Re: Objection to MP08_0244 MOD 1 Modification Request for Mixed Used Development at 23-37 Lindfield Avenue and 11 Havilah Lane, Lindfield

As a resident of Lindfield, I/we wish to lodge an objection against the proposed Modification of the subject development based on the following grounds:

1 SHADOW DIAGRAM - 21stDEC_9AM
5003 SCALE1 : 650

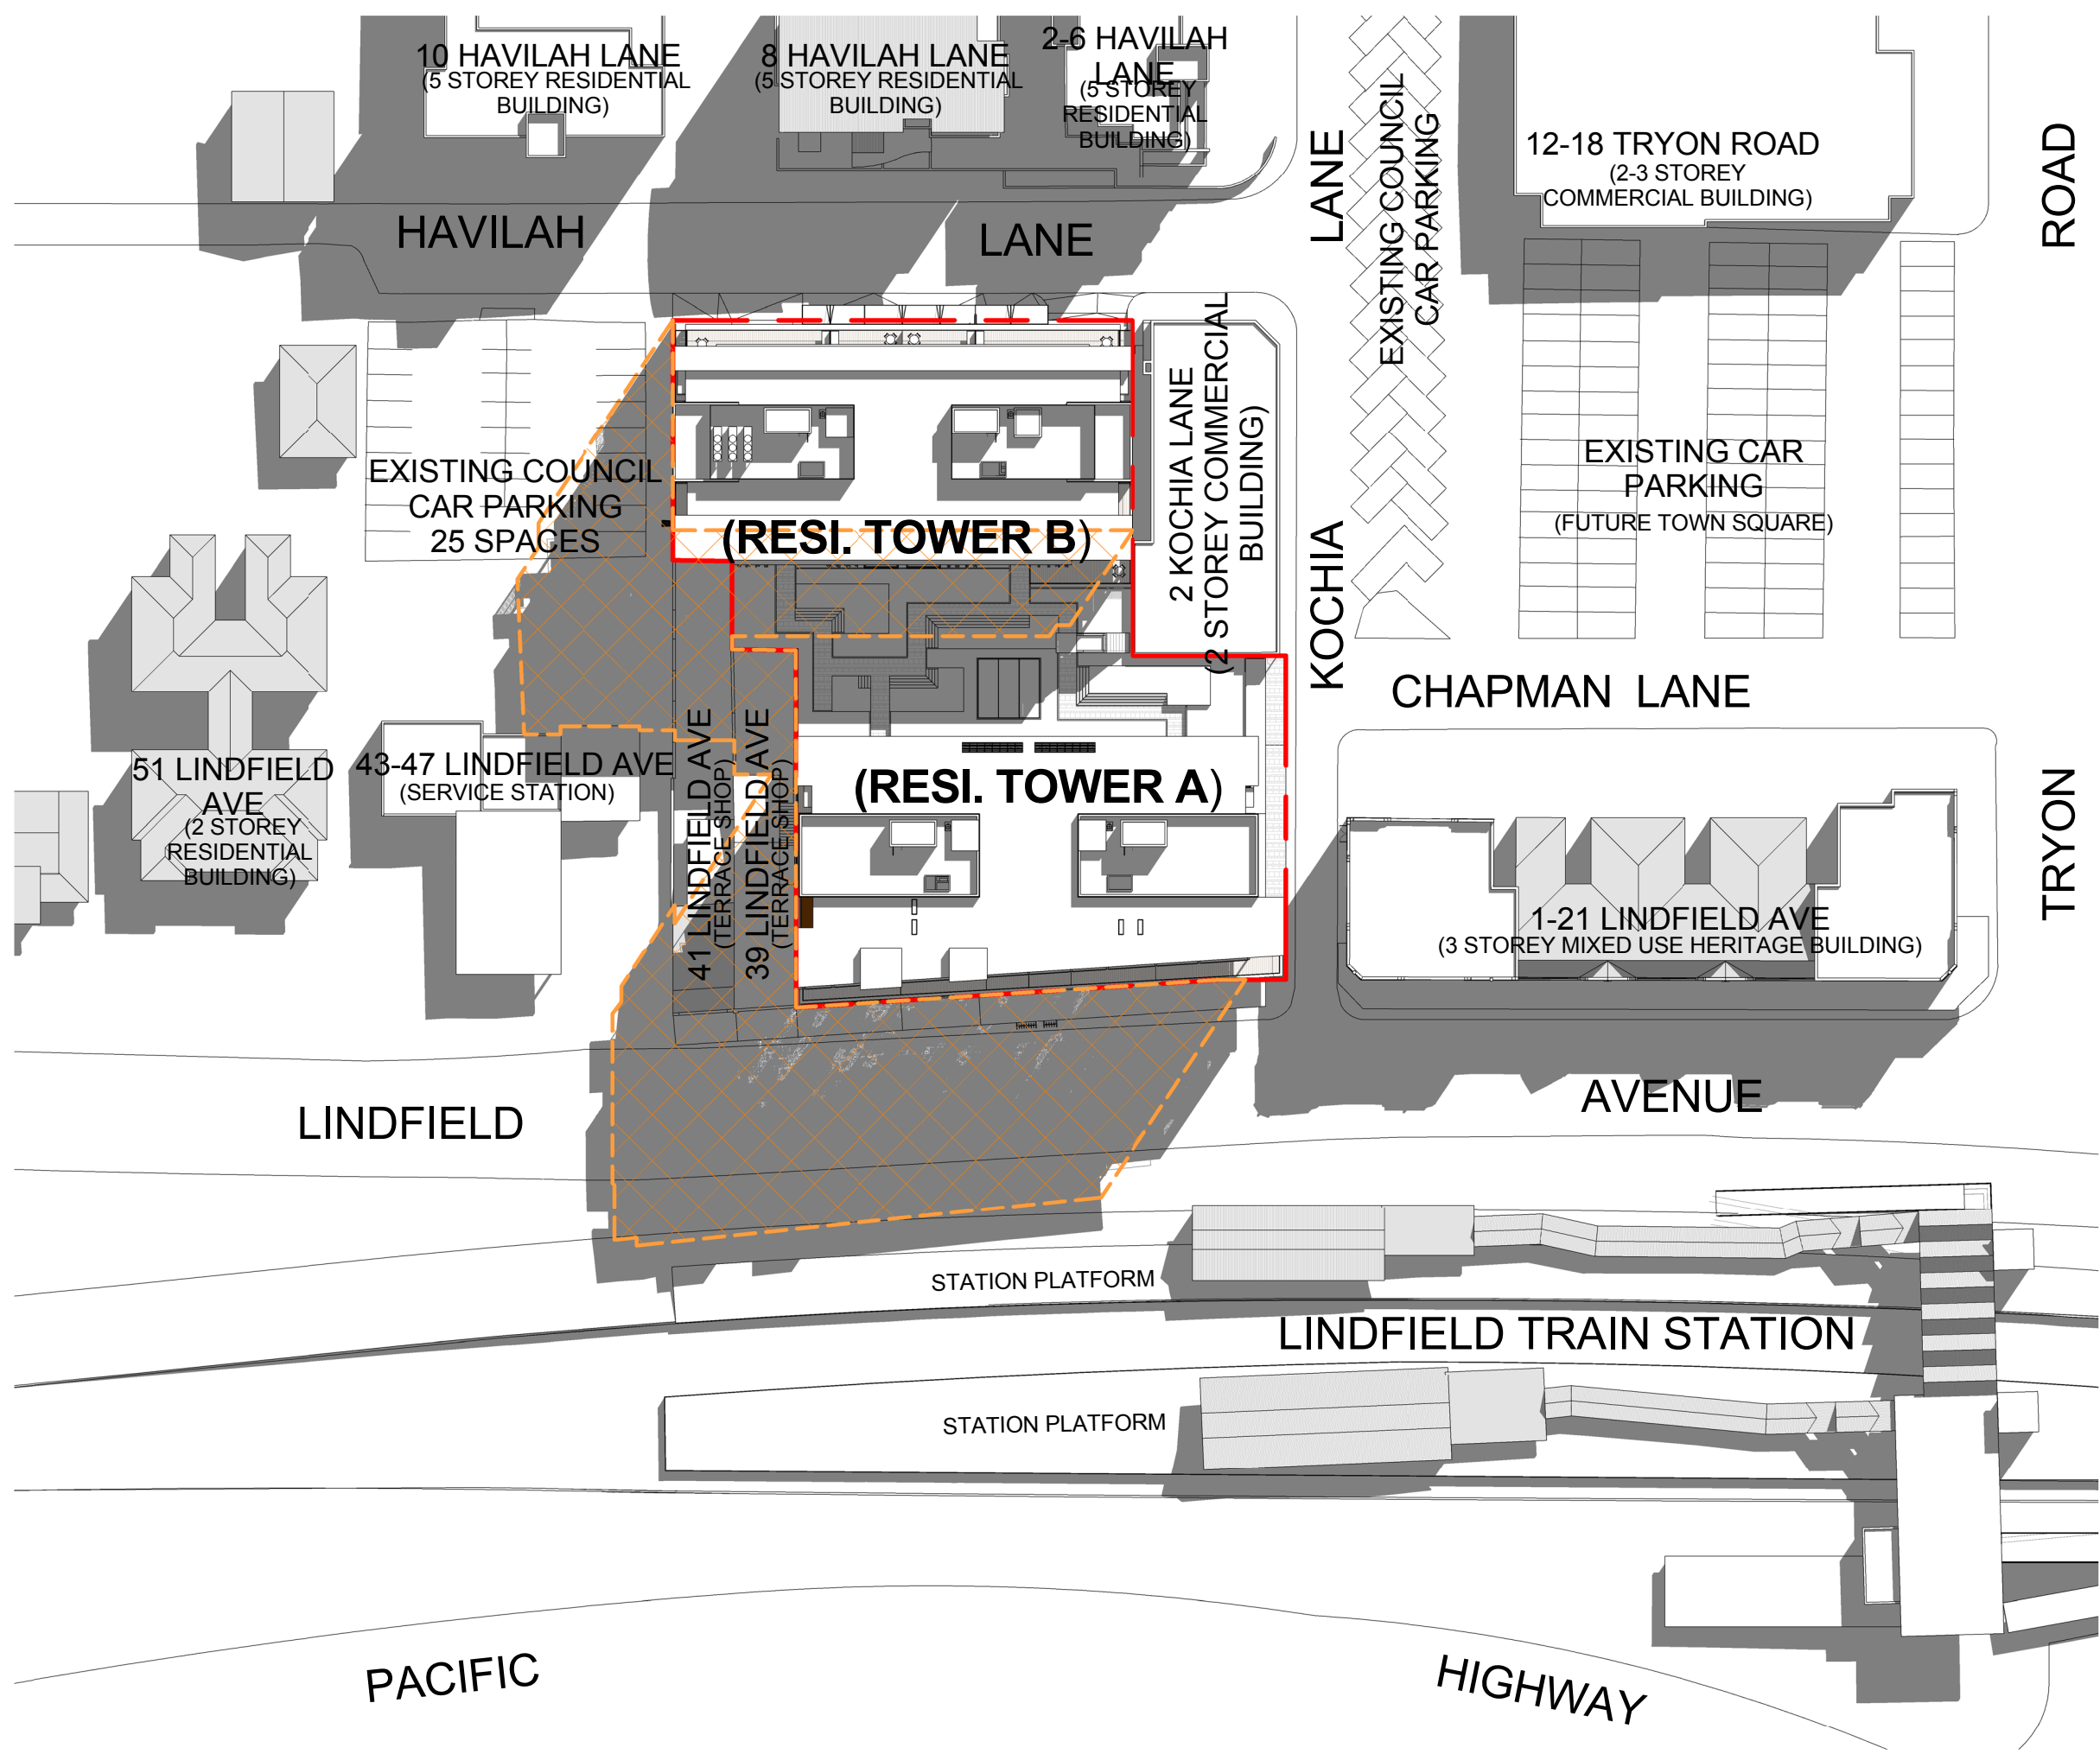
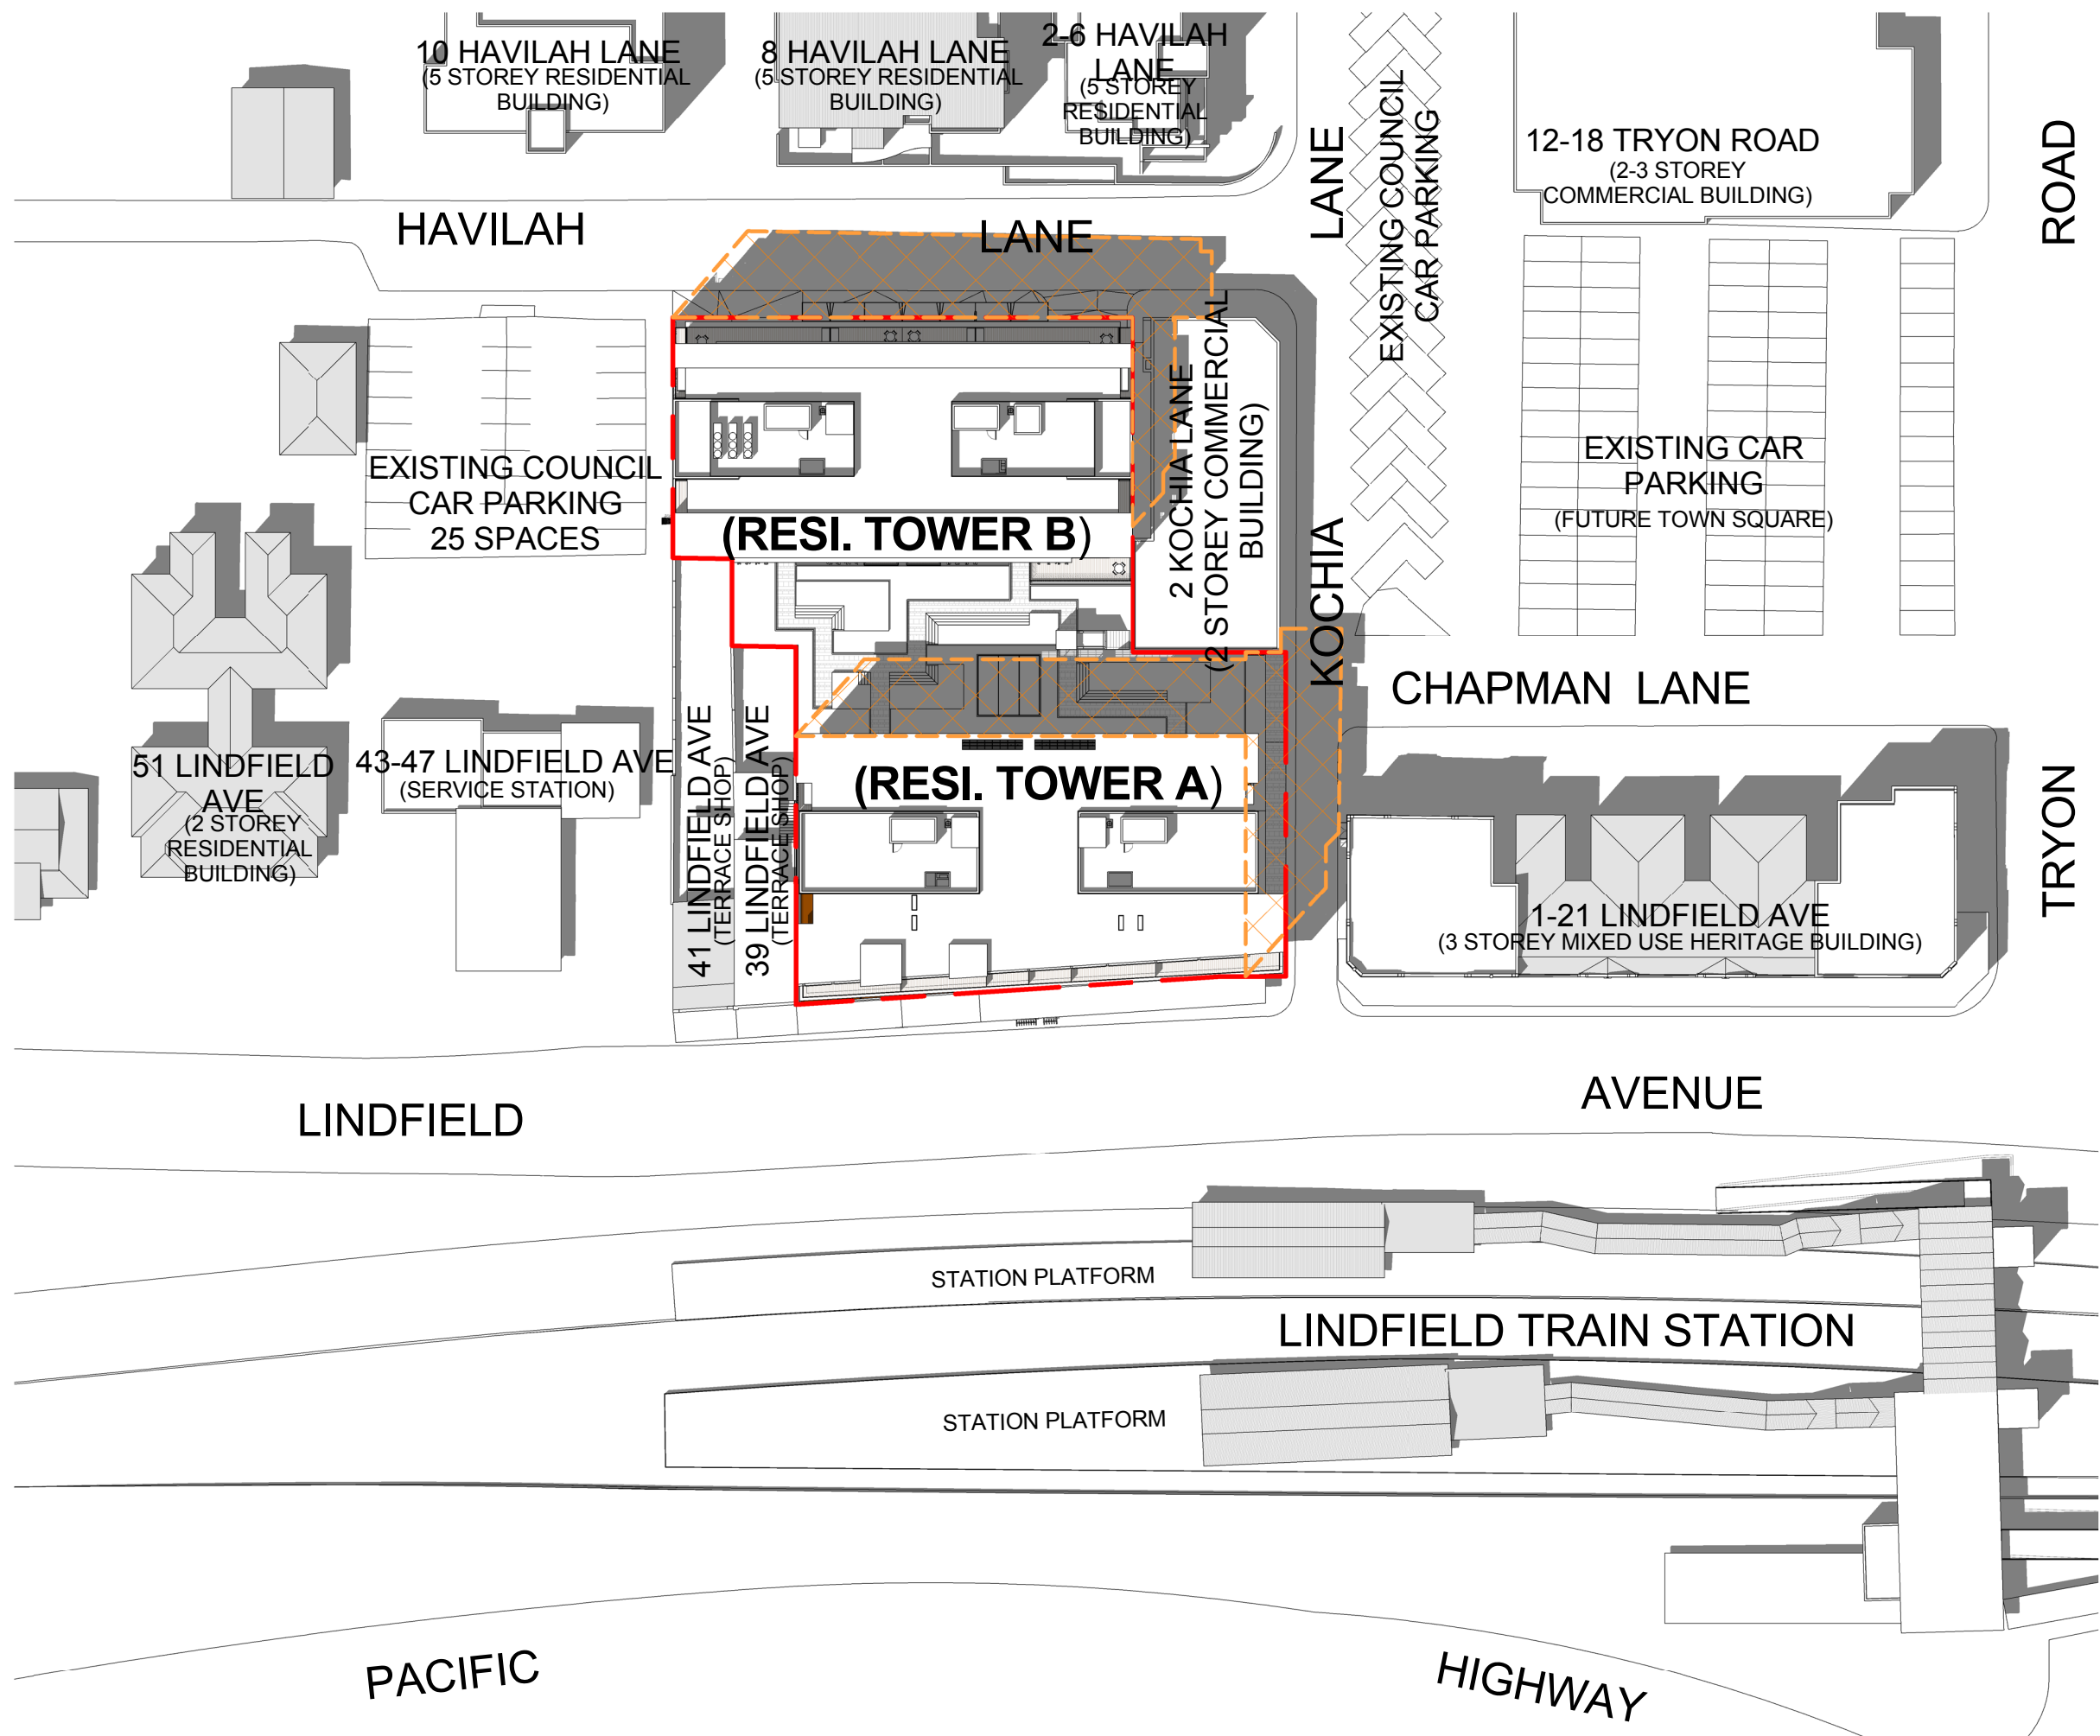
- The additional storeys create new adverse shadowing: a) for residents in the Havilah Lane apartments, particularly after 3pm b) for the popular outdoor café and central Lindfield hub area at 12 Tryon Road in afternoons, particularly in winter and c) for all commuters on the city bound Lindfield rail platform. Instead of 50% of the year as approved, it will now be in shadow in the mornings 75% of the year
